From: Laura Gibbons
Sent: 22 July 2019 13:56
To: Planning.Responses <Planning.Responses@arun.gov.uk>
Cc: Juan Baeza <Juan.Baeza@arun.gov.uk>
Subject: FW: Planning Consultation on: WA/44/19/PL

Engineers Amended Comments Regarding Surface Water Drainage

Site Address: Walberton Baptist Church The Street Walberton
BN18 0PG

Description of Works: Temporary permission (maximum 12 months) for
a single storey timber framed WC & lobby
extension. This application affects the character
& appearance of the Walberton Village
Conservation Area.

PROPOSED GROUND FLOOR PLAN

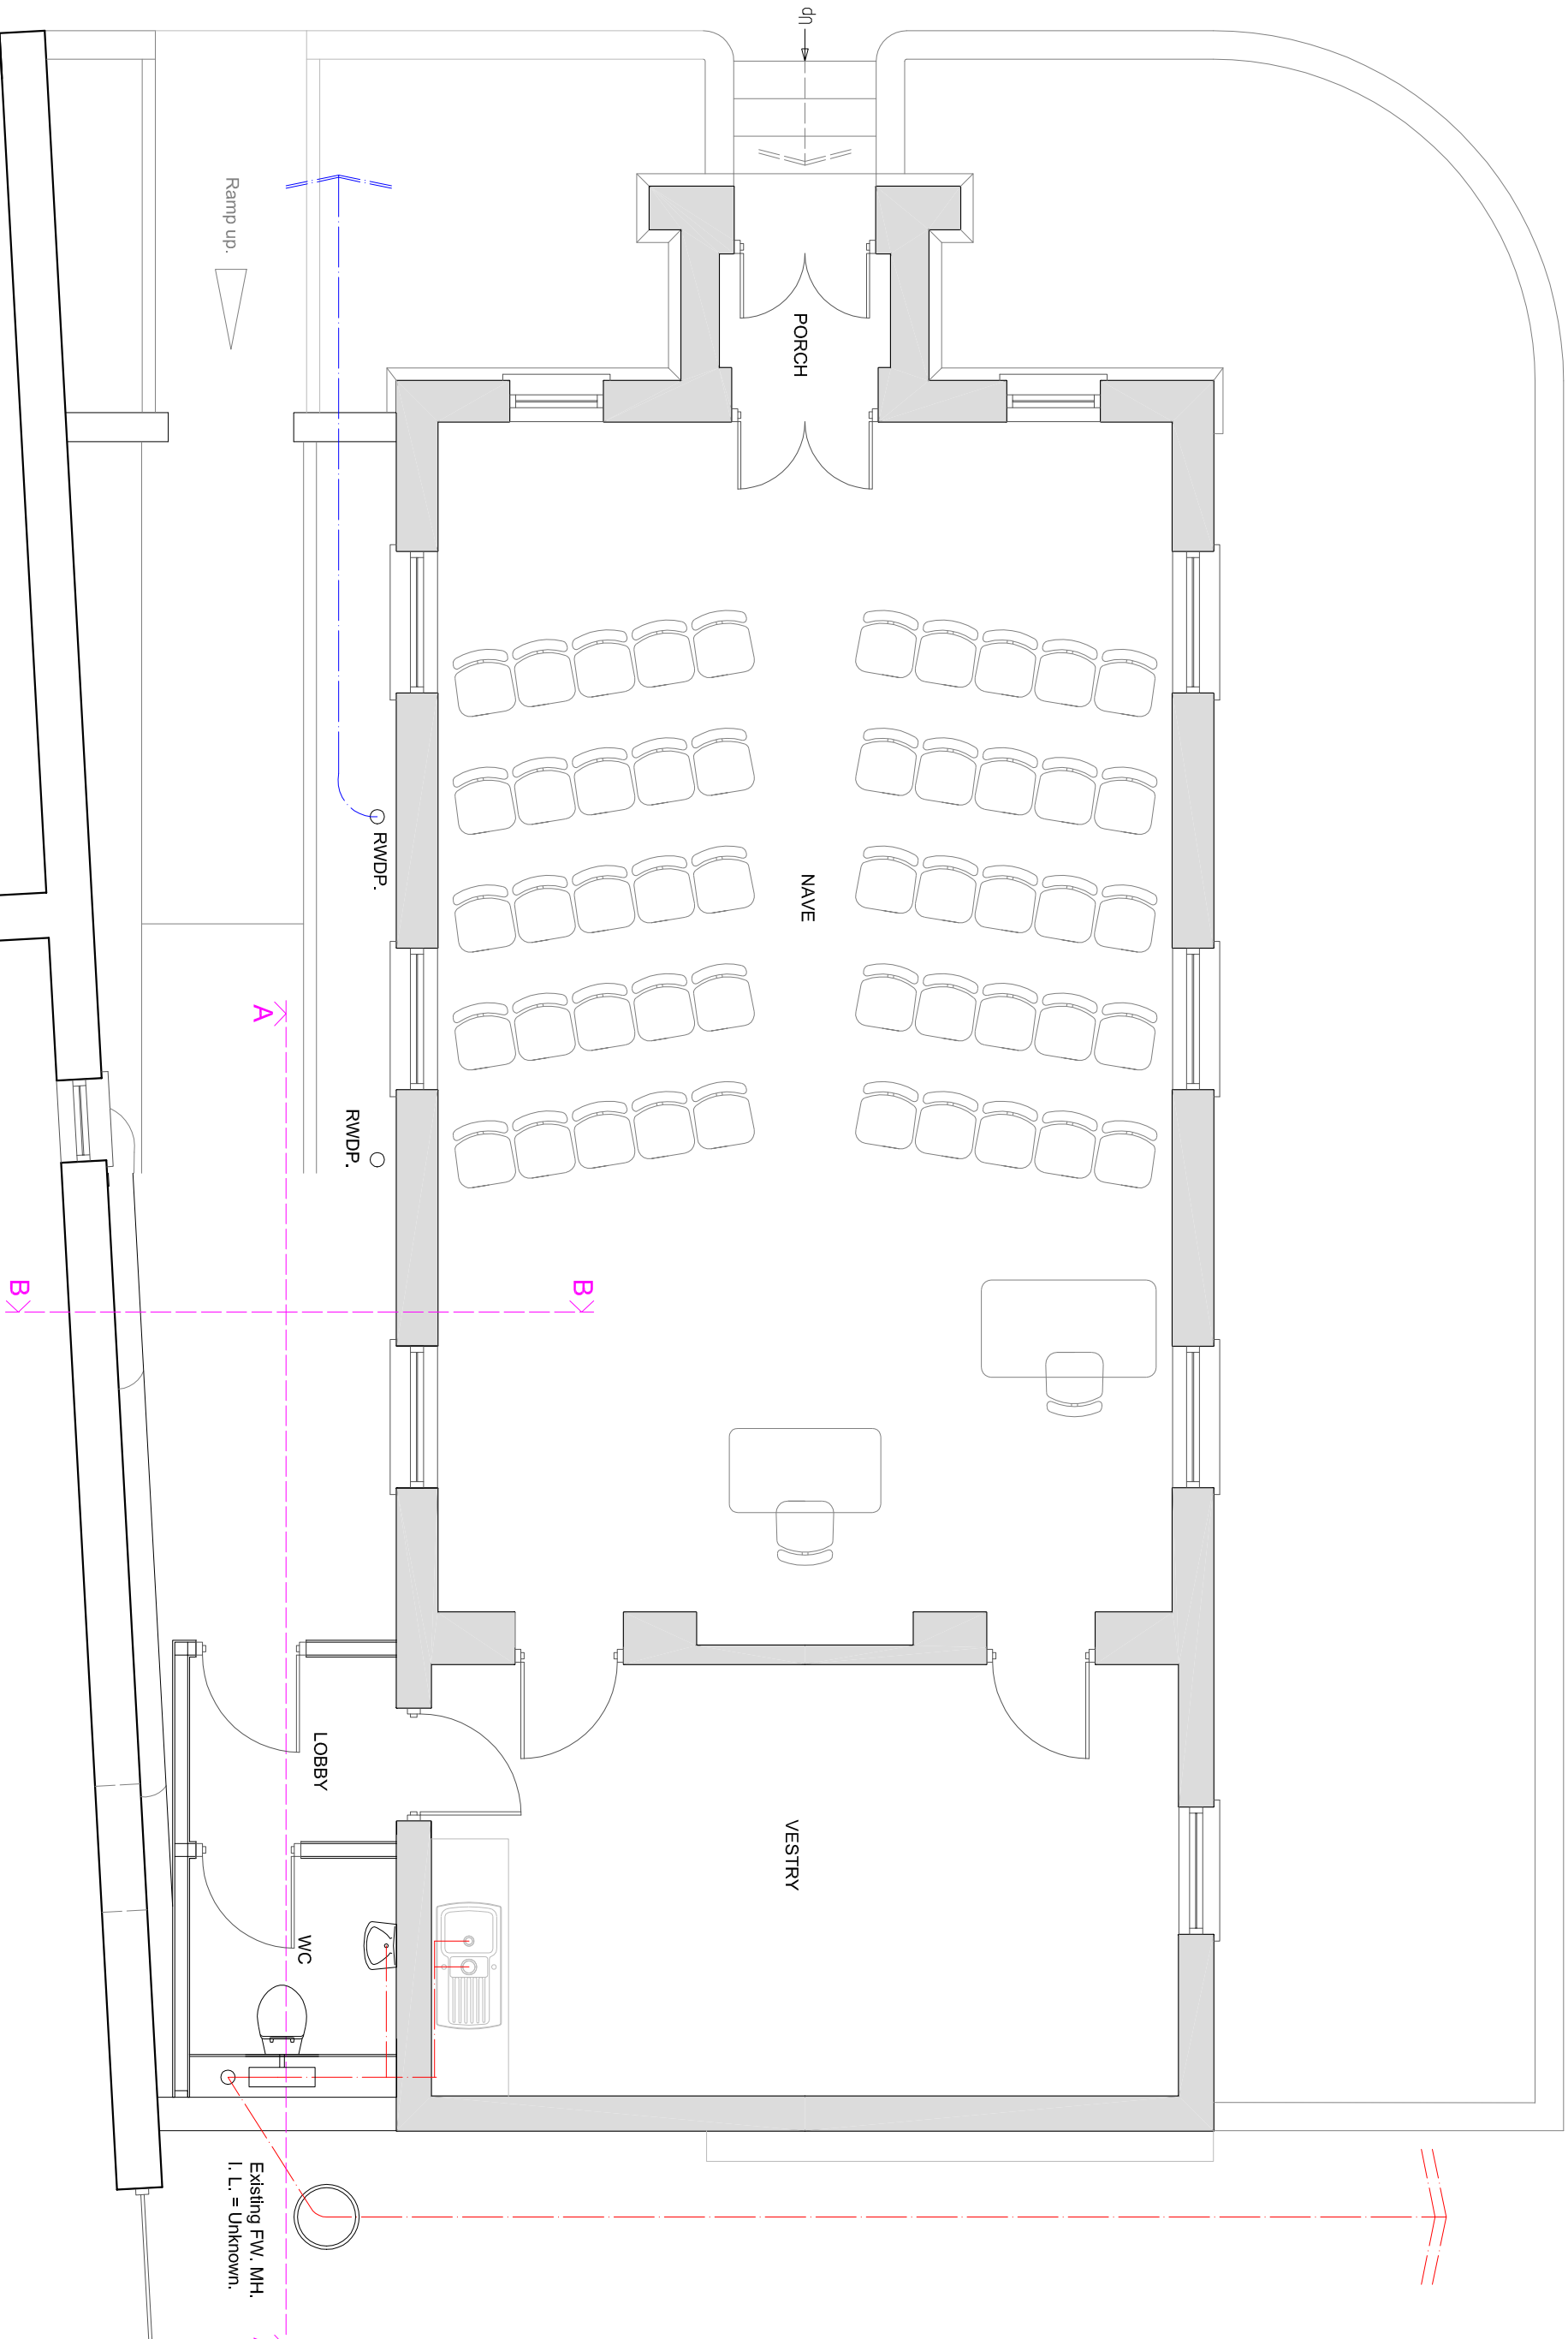
It has been brought to our attention that it will not be possible to drain the application in accordance with the details previously approved. Therefore, revised drainage plans should be submitted. As this is a retrospective application we would anticipate that these details are submitted prior to determination.

It would also be advisable to request that the applicant submits details of the foul drainage arrangement and evidence that the necessary permissions from Southern Water have been obtained.
